KIRKLEES METROPOLITAN COUNCIL INVESTMENT & REGENERATION SERVICE

DELEGATED DECISION TO DETERMINE APPLICATIONS FOR LISTED BUILDING CONSENT

Reference No:	2026/65/90008/W
Site Address:	Mount Pleasant, Moorside Edge, Moor Side Lane, Slaithwaite, Huddersfield, HD7 5UU
Description:	Listed Building Consent for Installation of 4 CCTV cameras and 1 new kitchen ventilation extract
Recommending Officer:	Joshua Merriman

Officer Report – 2026/90008

MOUNT PLEASANT
04 - Proposed Plans
1:100 @ A3

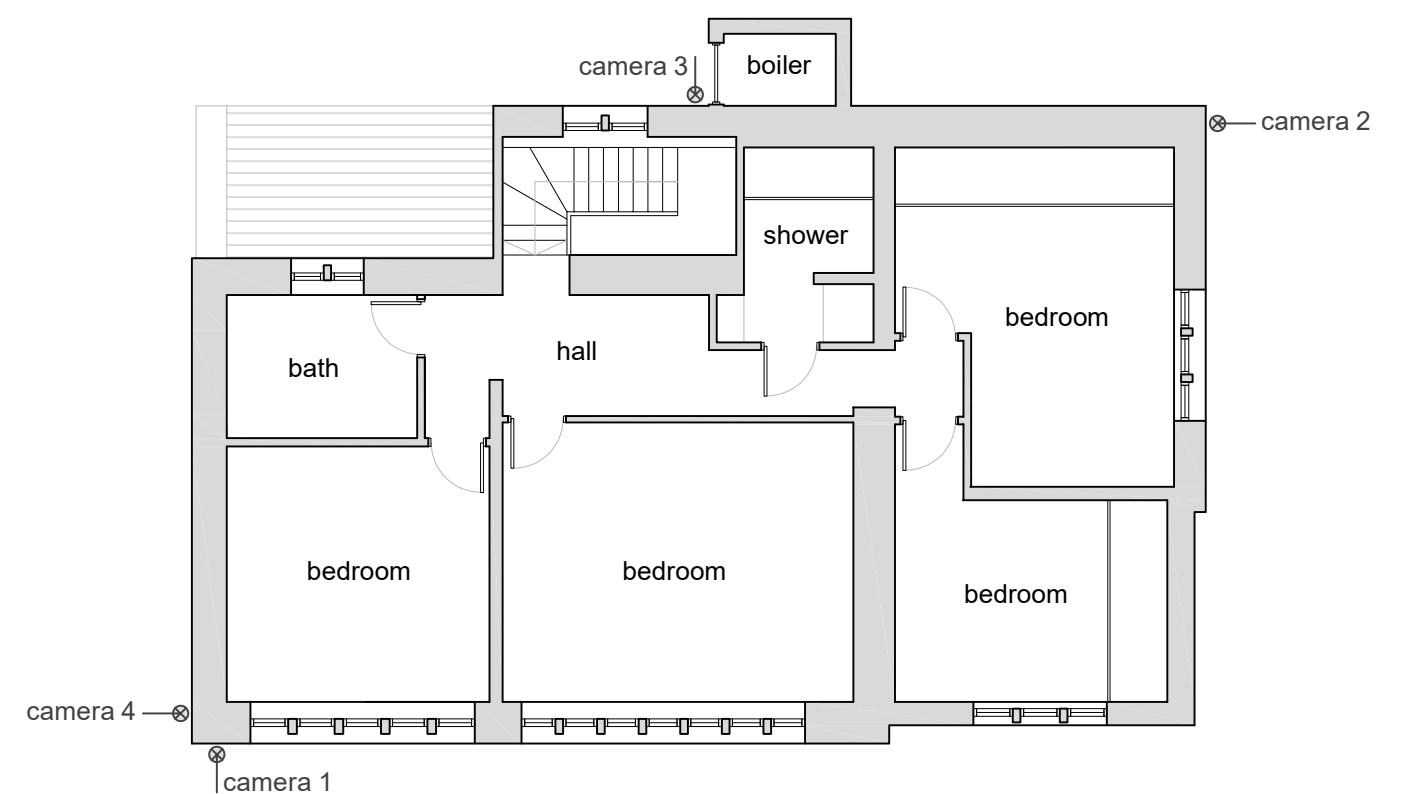
The proposed changes to the property include the installation of kitchen extract vent to the North elevation, and 4 CCTV cameras around the property located on the North, East, South, and West elevations of the building. All the proposed installations are limited in scale and are not considered to

Following an informal consultation with KC Conservation & Design, there were no objections to the proposal, subject to conditions being added ensuring the kitchen ventilation extract is black or stone in colour, and the CCTV cameras are black in colour, installed through mortar joints using lime mortar, and use non-ferris fixings.

4. The CCTV cameras hereby approved should be of a black colour finish, with non-ferrous fixings which shall be within mortar joints only.
